**WELWYN HATFIELD BOROUGH COUNCIL
EXECUTIVE DIRECTOR - PLANNING, PUBLIC PROTECTION AND GOVERNANCE**

Application No: 6/2018/0642/VAR
Location: 37 Broadwater Road Welwyn Garden City AL7 3AX
Proposal: Variation of condition 16 (approved plans) on planning permission 6/2016/2497/MAJ
Officer: Ms Louise Sahlke

Recommendation: Refused

drawing title
PROPOSED ELEVATIONS

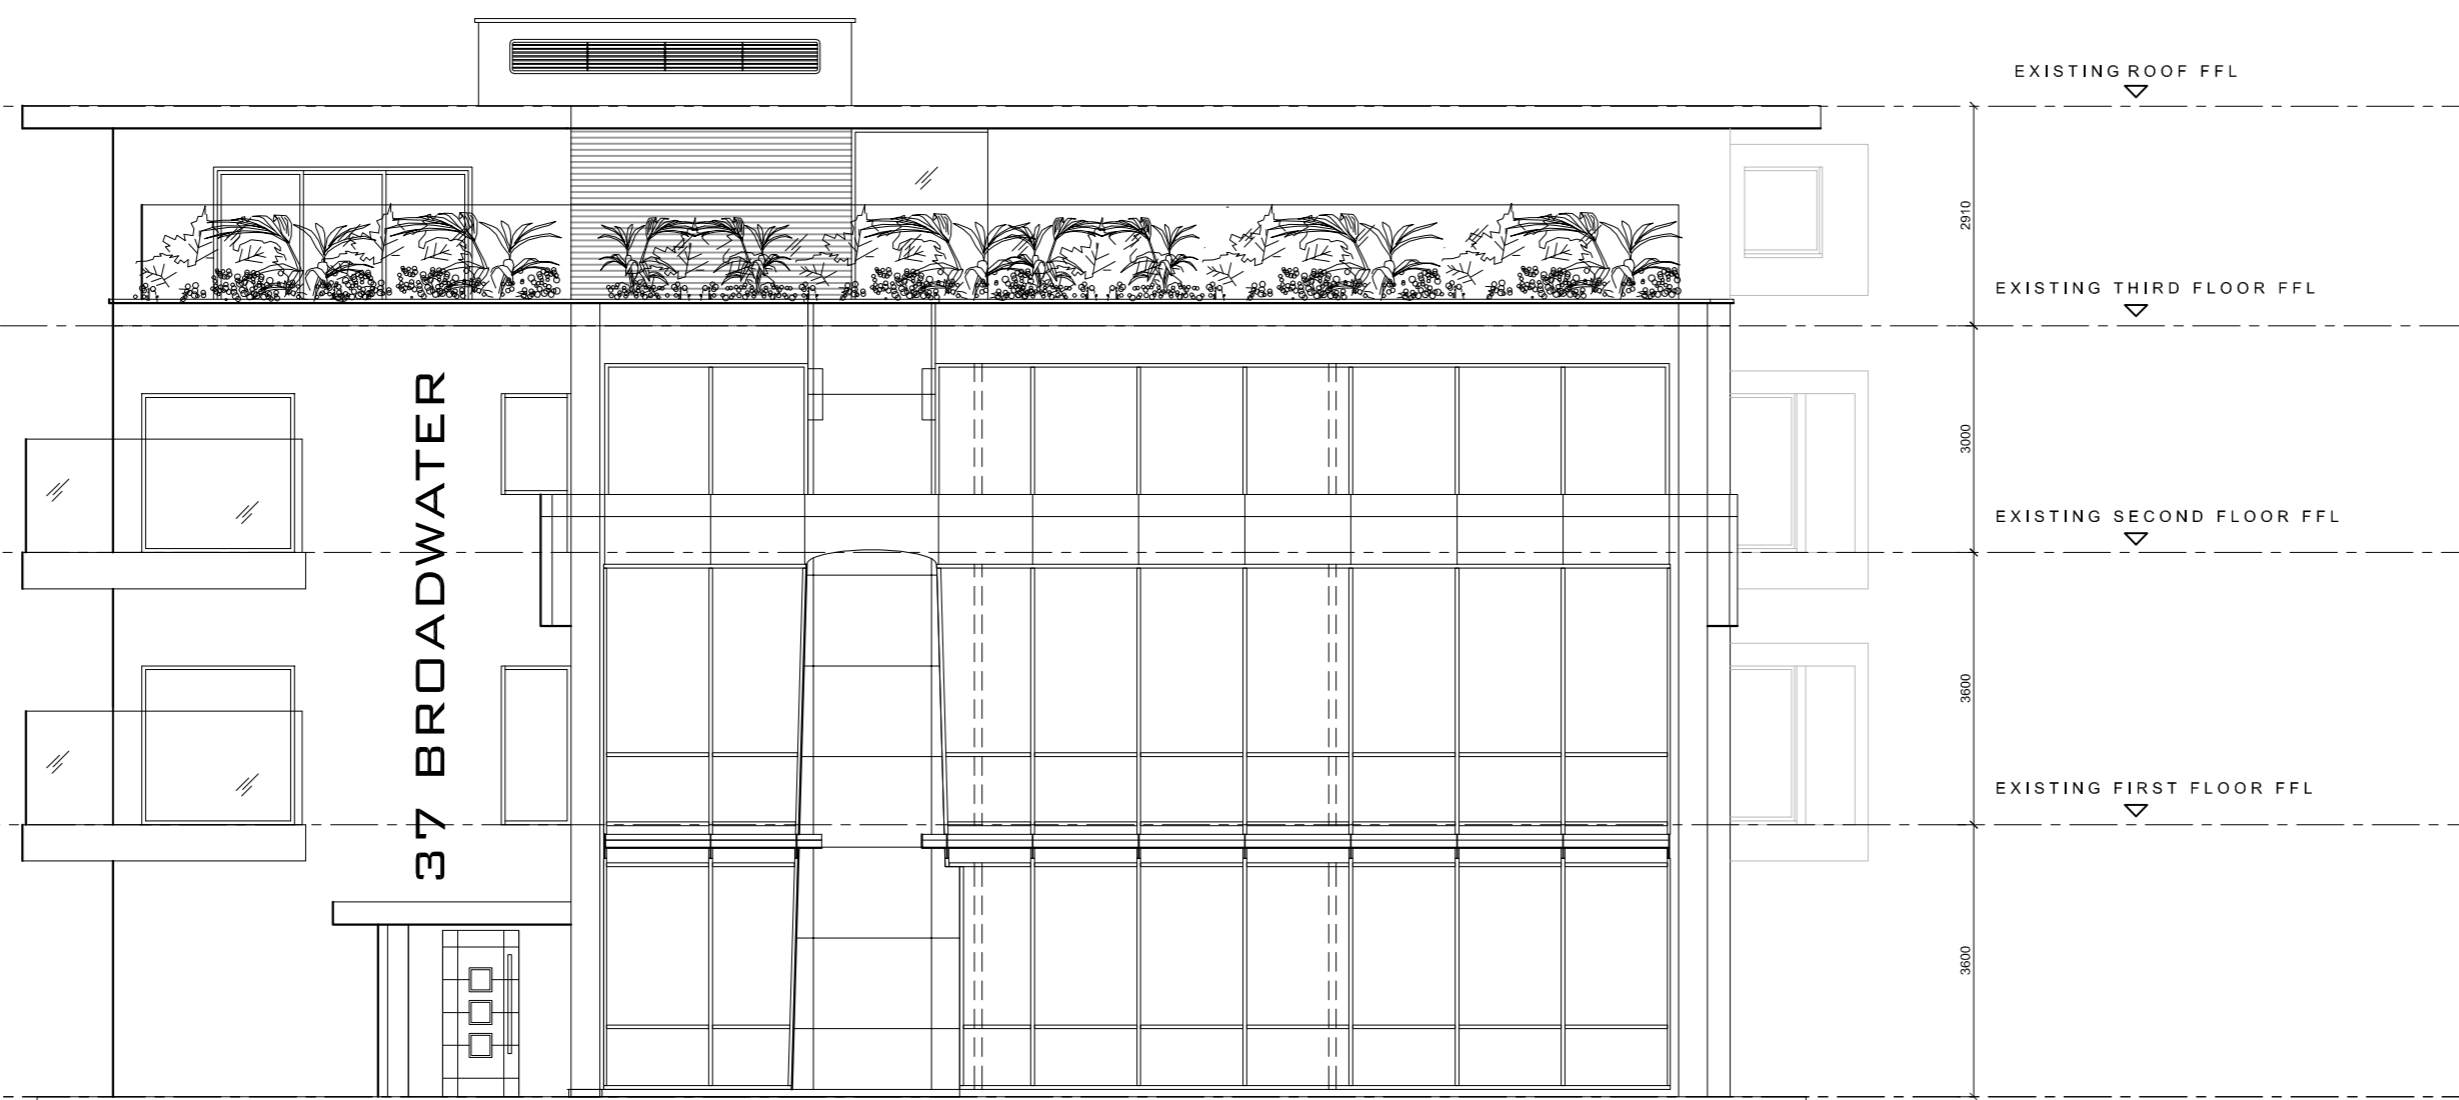
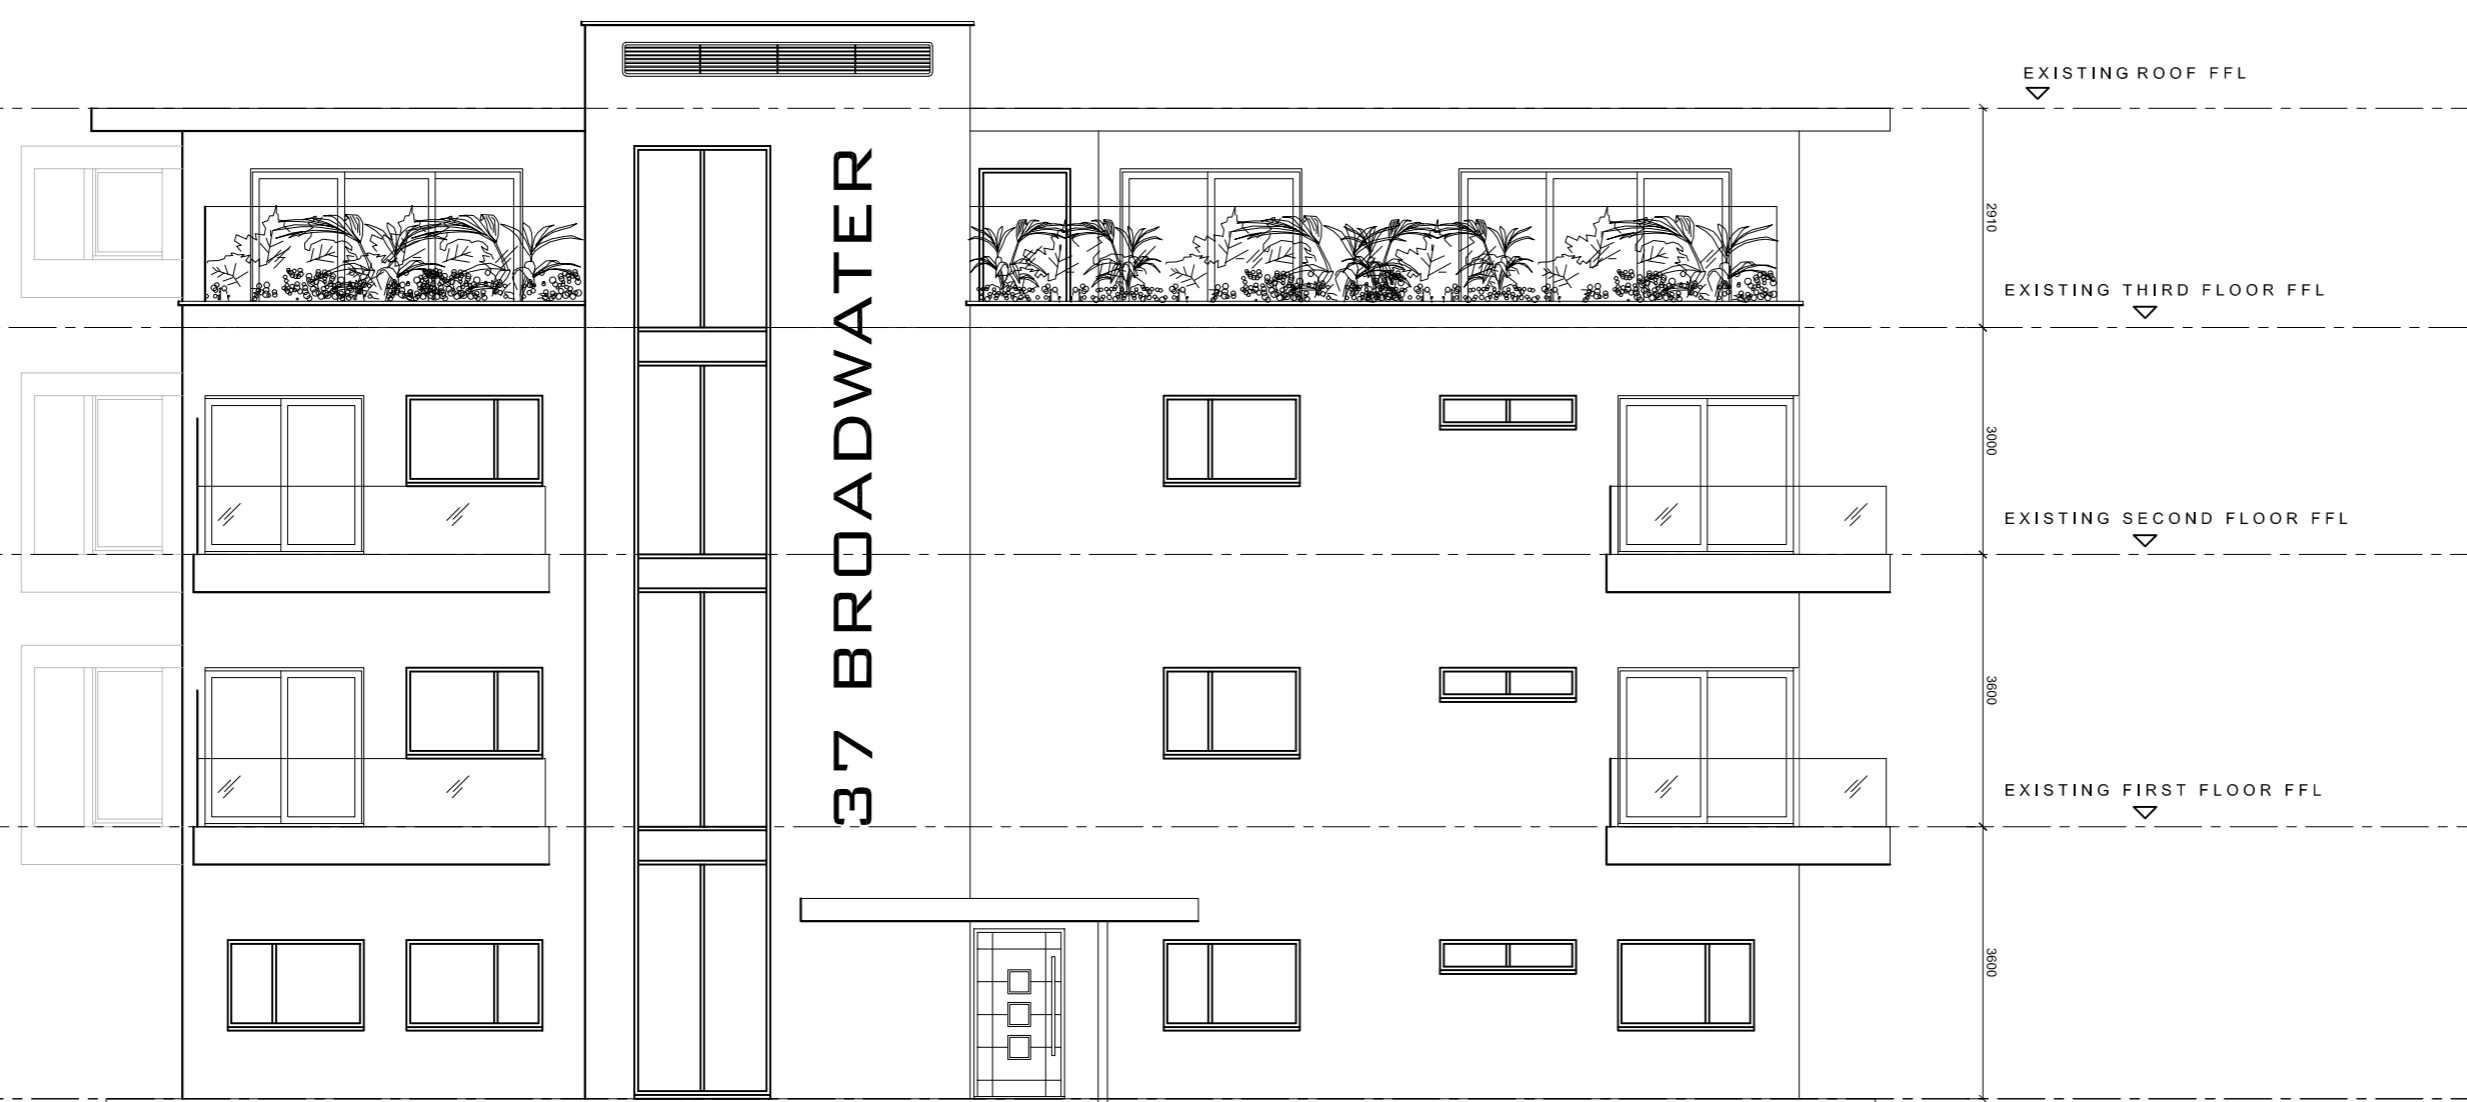
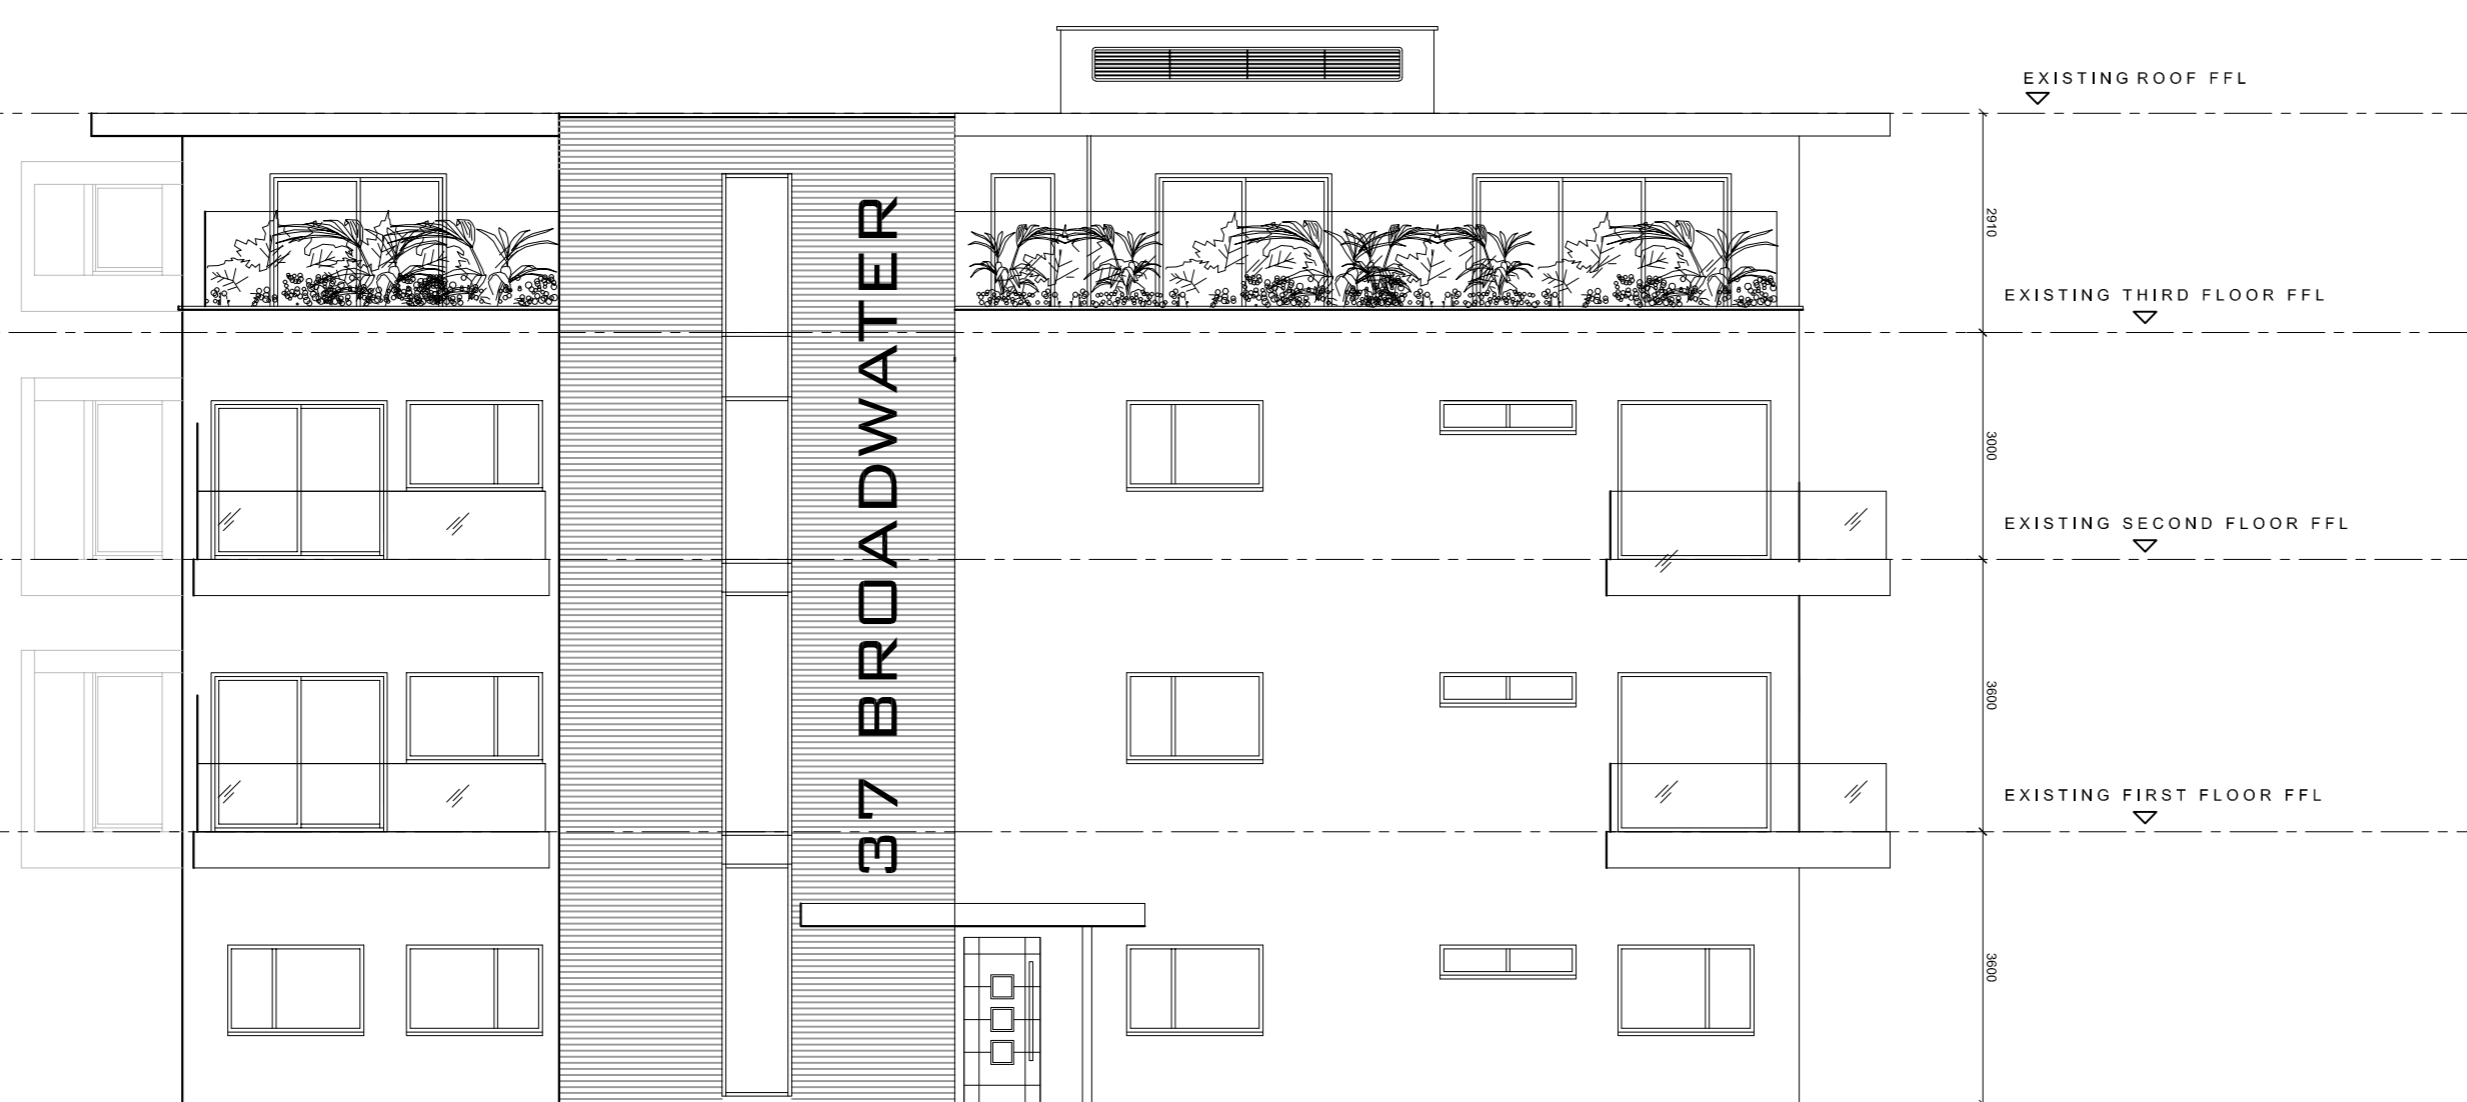
Main Issues	
Background	<p>The Case Officer has noted that there are minor amendments to the proposed elevations when compared to the approved plans. These have not been applied for under this application. However as these are demonstrated clearly on the plans, it is considered that assessment can be undertaken and further neighbour consultation is not required.</p>
Whether the site is required to meet future employment requirements and business and community needs	<p>The principle of development was discussed under planning application reference 6/2016/2497/MAJ. The loss of the site to residential use within the employment area was assessed against both Policy EMP2 of the District Plan 2005 and Policy SADM10 of the Draft Local Plan Proposed Submission 2016.</p> <p>It is not considered that there is any material change in planning policy which would impact on the principle of development. Therefore it remains that the employment use of the building has effectively ceased. Therefore the principle of development is considered acceptable in regards to the National Planning Policy Framework 2012, Policy EMP2 of the District Plan 2005 and Policy SADM10 of the Draft Local Plan Proposed Submission 2016.</p>

<p>In relation to the elevational changes to the scheme, these would not negatively alter the contextual design and built form of the proposal. The proposed elevational alterations would not significantly impact upon any of the other material considerations that were relevant under the original application. These considerations weigh substantially in favour of the scheme.</p> <p>The sedum roof was considered to soften the bulk and mass of the proposal and to match those on the opposite side of the road and to ensure that the proposal is in keeping with the key, soft landscaping ethos of the garden city. The change of the sedum roof to a single ply roof would not be highly visible from the public realm and therefore on balance its removal is considered acceptable.</p> <p>The internal alterations to the built form are considered acceptable and are not considered to impact on the bulk, size and massing of the proposal.</p> <p>The NPPG governs the use of conditions in planning and the power to impose conditions when granting planning permission is very wide. If used properly, conditions can enhance the quality of development and enable many development proposals to proceed where it would otherwise have been necessary to refuse planning permission. The objectives of planning, however, are best served when that power is exercised in such a way that conditions are seen to be fair, reasonable and practicable. Conditions should only be imposed where they are necessary and reasonable, as well as enforceable, precise and relevant both to planning and to the development to be permitted. In relation to this proposal, a successful application to amend conditions results in the issue of what is in effect a new planning permission, but does not cancel the old permission.</p> <p>It is reasonable therefore that the current planning application should be subject to the same conditions as the previous planning application, 6/2016/2497/MAJ whereby conditions were applied, as they remain in accordance with the tests set out in paragraph 206 of the NPPF.</p> <p>It is recommended that suitably worded conditions are attached to ensure compliance with the approved details. Where conditions have been agreed, their wording has been amended accordingly.</p> <p>Therefore subject to conditions, the proposal is considered acceptable in regards to the National Planning Policy Framework 2012, Policies D1, D2 and D8 of the District Plan 2005 and Policies SADM SP9, SP10, SADM11 and SADM12 of the Draft Local Plan Proposed Submission 2016.</p>
